KITTITAS COUNTY
DEPARTMENT OF PUBLIC WORKS

RE: Wenger Short Plat

Prior to conditional approval of the Wenger Short Plat, the Kittitas County Department of Public Works requests the following information:

WENGER SHORT PLAT
KITTITAS COUNTY SHORT PLAT NO. 07-XX
PORTION OF THE NE 1/4, SEC.29 T.20N., R.14E., W.M.
KITTITAS COUNTY, WASHINGTON

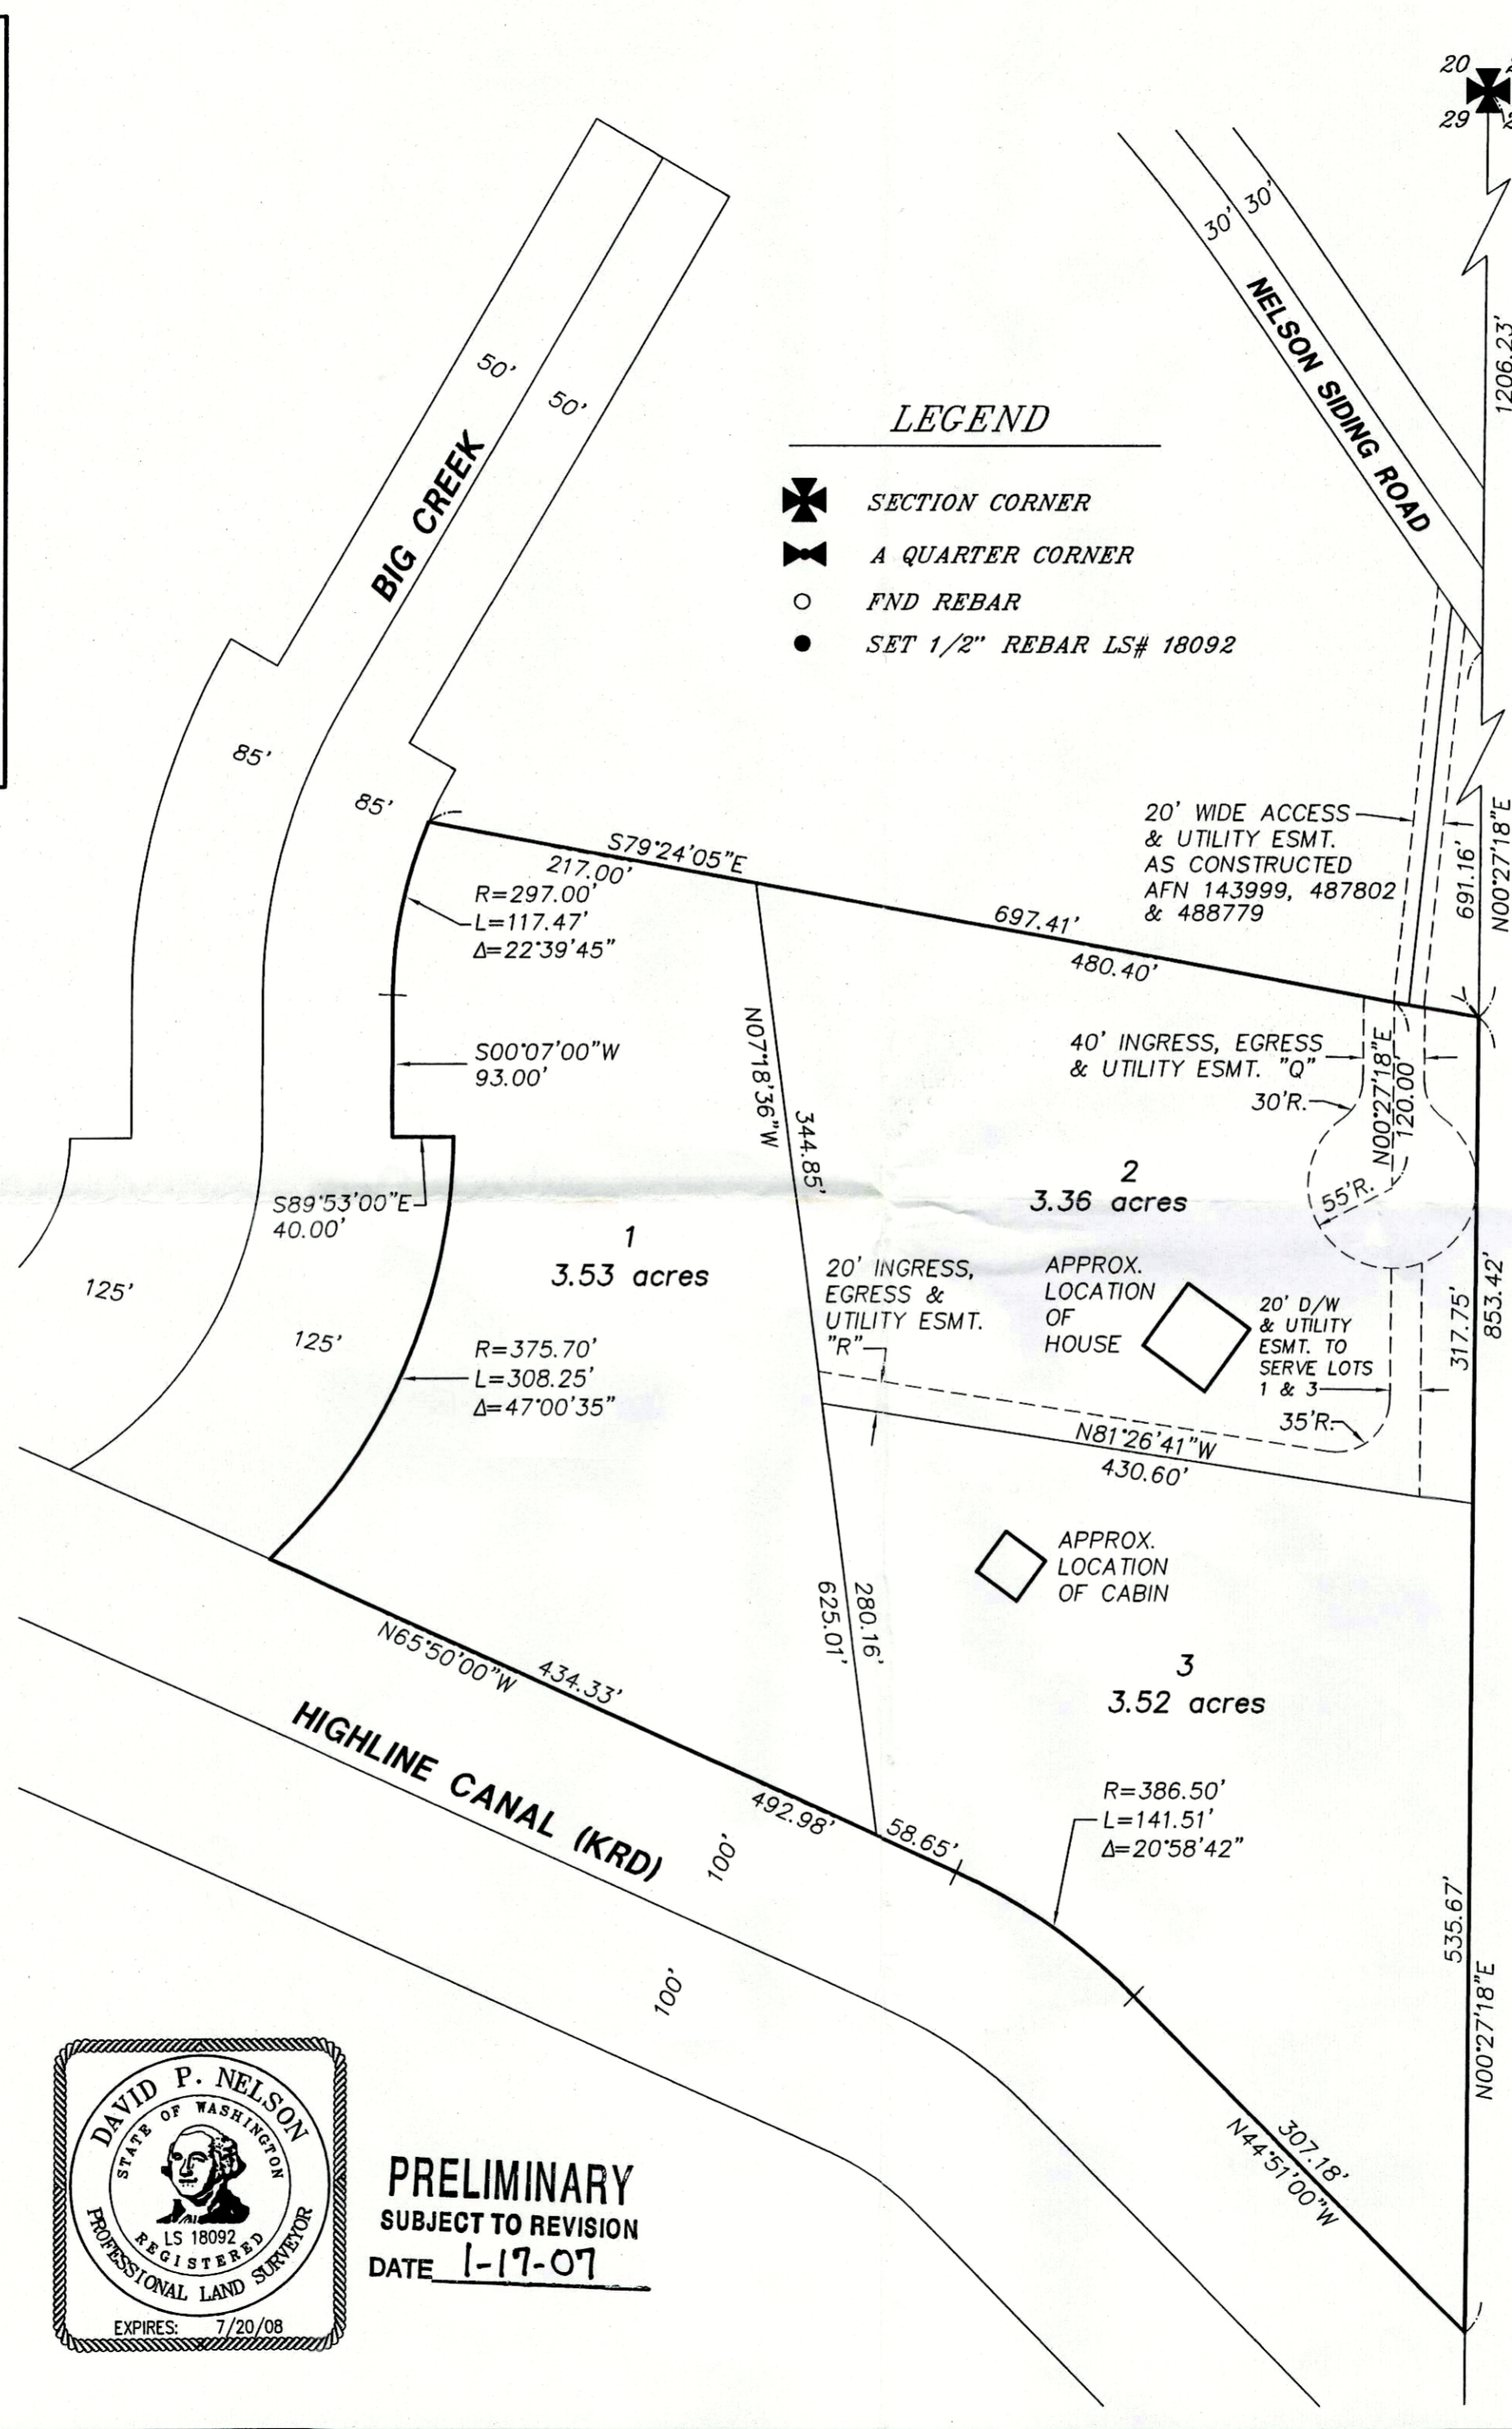
Documentation of a 40' access easement to tax lot 20-14-29010-0010.

AFN 488779 grants a 20' access easement to tax lot 20-14-29010-0010. Kittitas County Road Standards require that this access easement be a minimum of 40' (KCRS, 9/6/05 edition, Table 12-1, High-Density Private Road serving 3-14 lots). Per KCC 12.01.095(7), this documentation is required before final approval.

KCC 12.01.095(7): All parcel creations that access property over private lands, public lands, or road easements managed by other agencies must submit an approved easement from the land owners or road/easement managers that specifically address access, maintenance, seasonal restrictions and other restrictions and or limitations. These easements and permits shall be presented or recorded prior to final approval.
